FALCON MEADOWS AT BENT GRASS FILING NO. 2

A REPLAT OF TRACT G, BENT GRASS RESIDENTIAL FILING NO. 2 AND
A PORTION OF THE WEST HALF OF SECTION 1,
TOWNSHIP 13 SOUTH, RANGE 65 WEST OF THE 6TH PRINCIPAL MERIDIAN,
COUNTY OF EL PASO, STATE OF COLORADO

# FALCON MEADOWS AT BENT GRASS

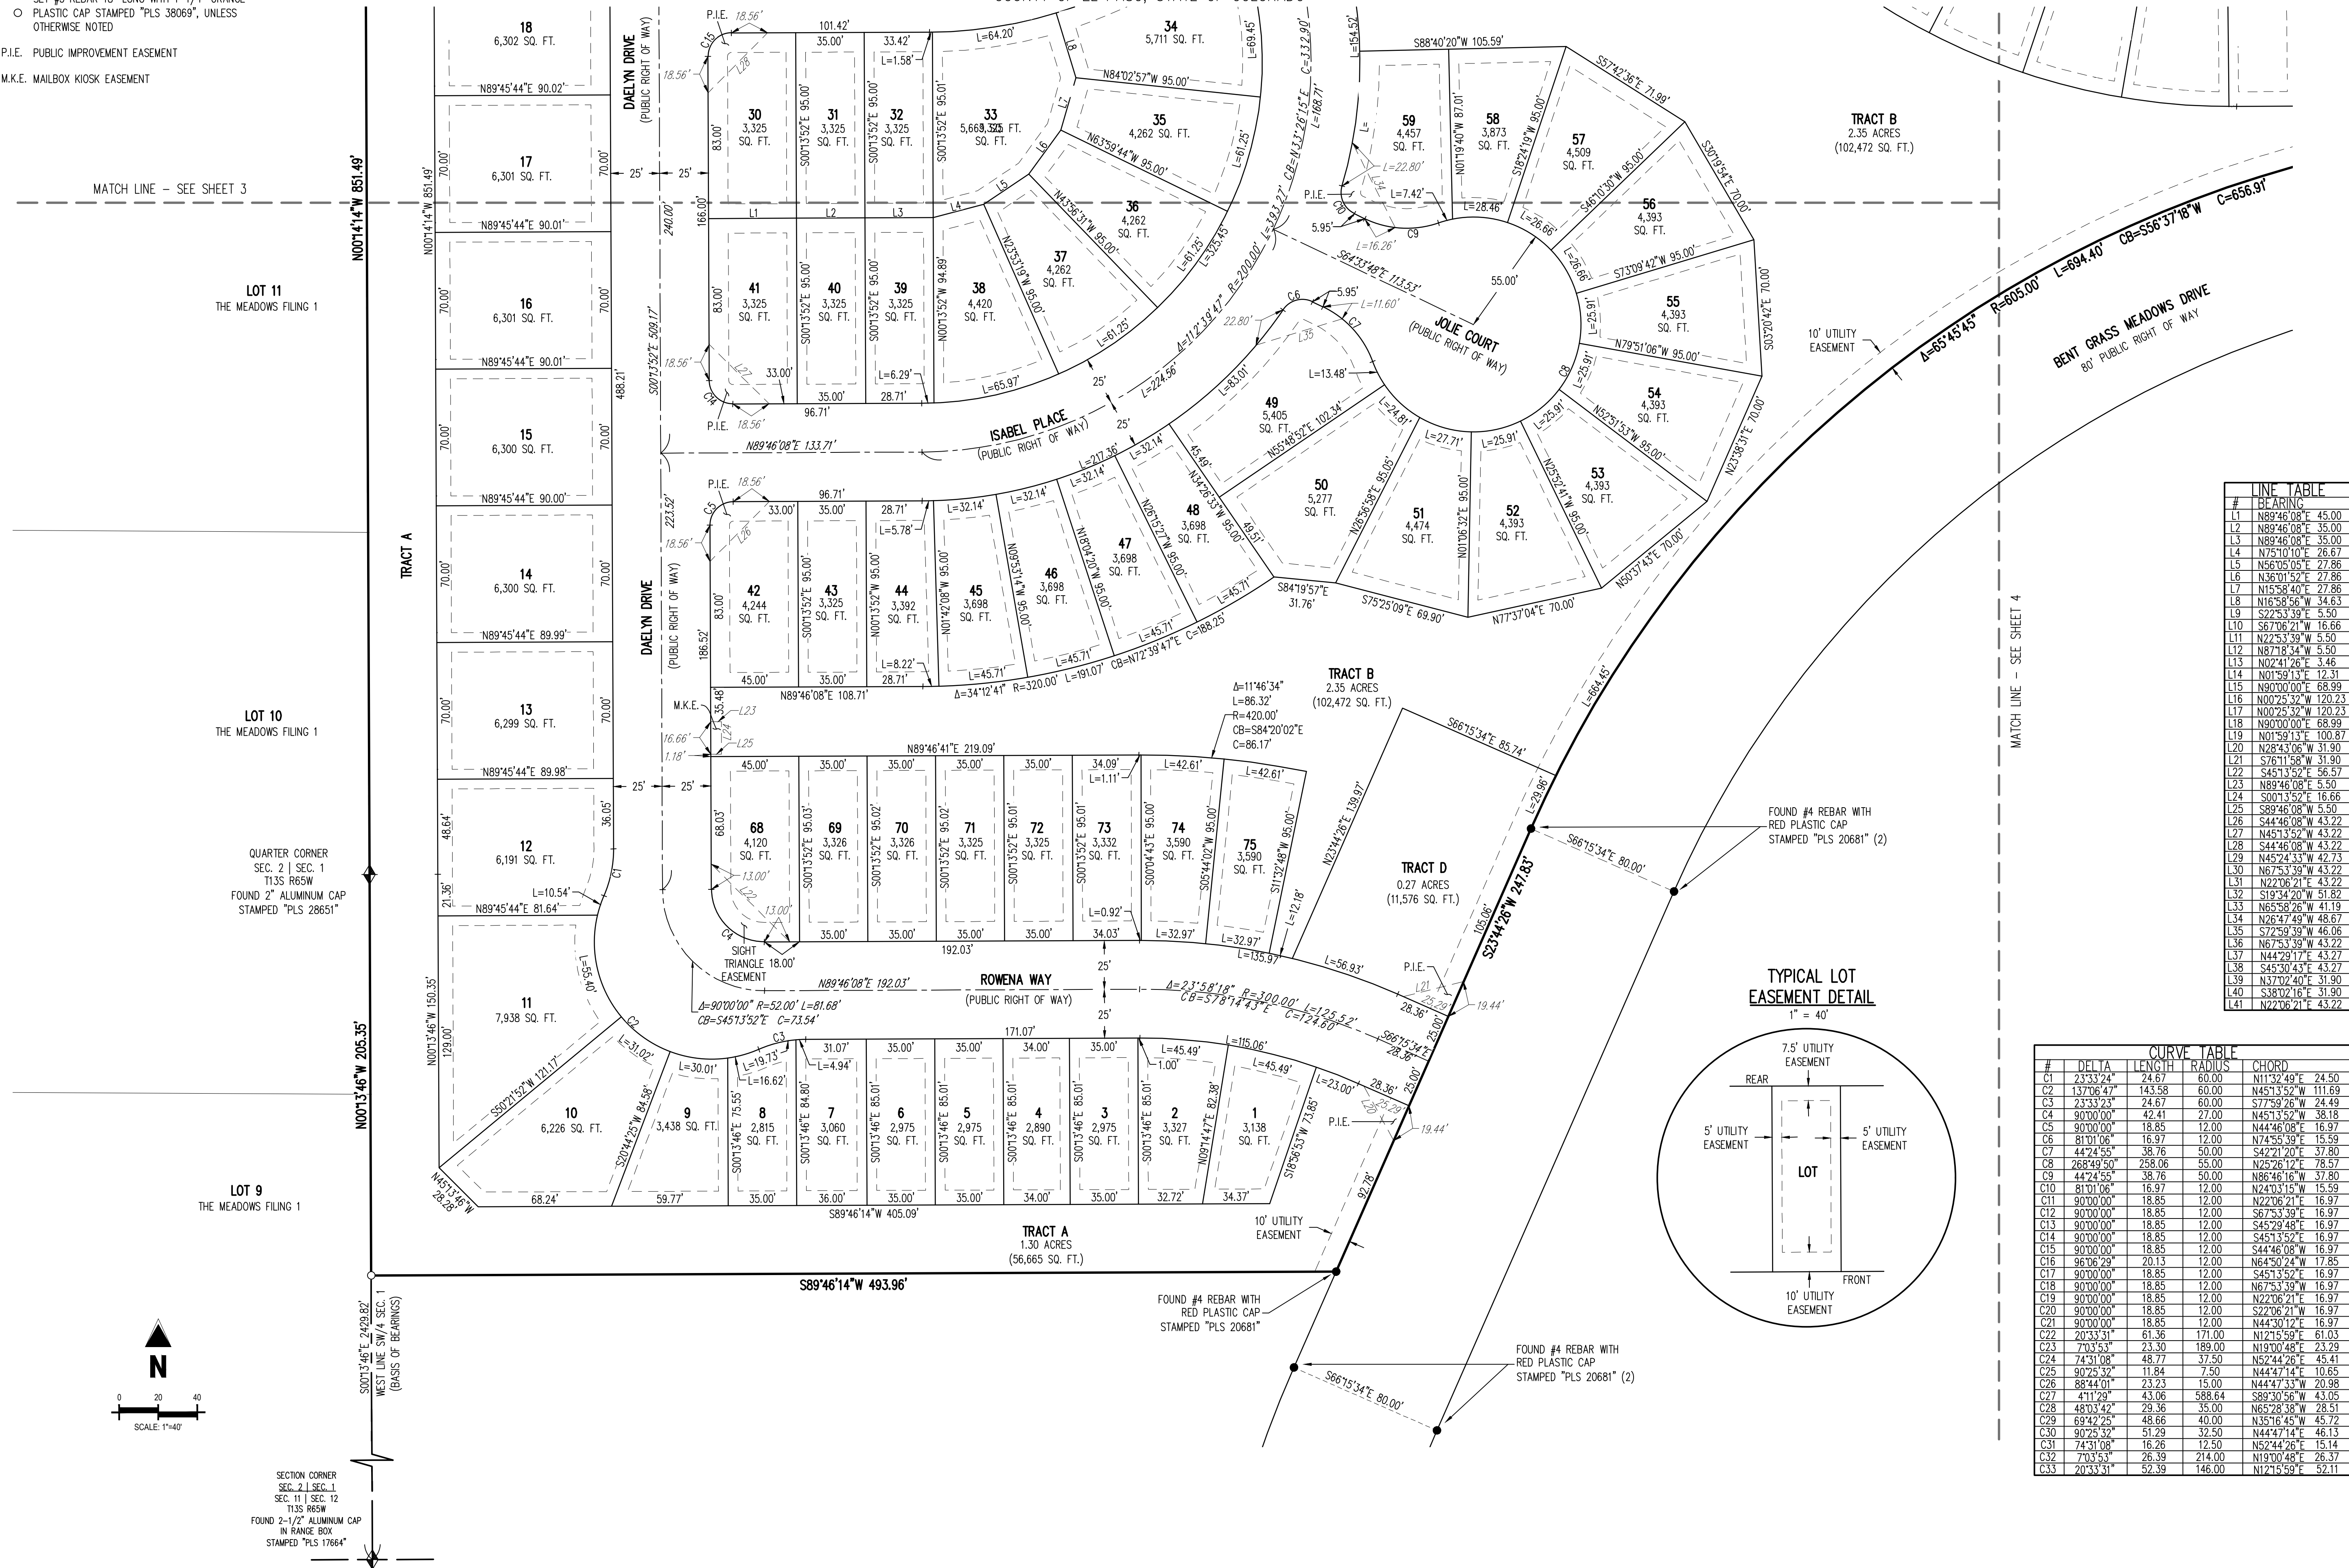
ALL ACCESS ROADS SHOULD BE NOTED ON PLAT

PROVIDE A NOTE FOR INSTALLATION AND MAINTENANCE RESPONSIBILITIES FOR TWO TYPES OF FENCES ON SHEET 1 OR 2; ADD EACH TO FAE

TRAIL NOTES SHOULD BE ADDED: WHO BUILDS AND MAINTAINS- COST SHOULD BE INCLUDED IN FAE

also show drainage easement
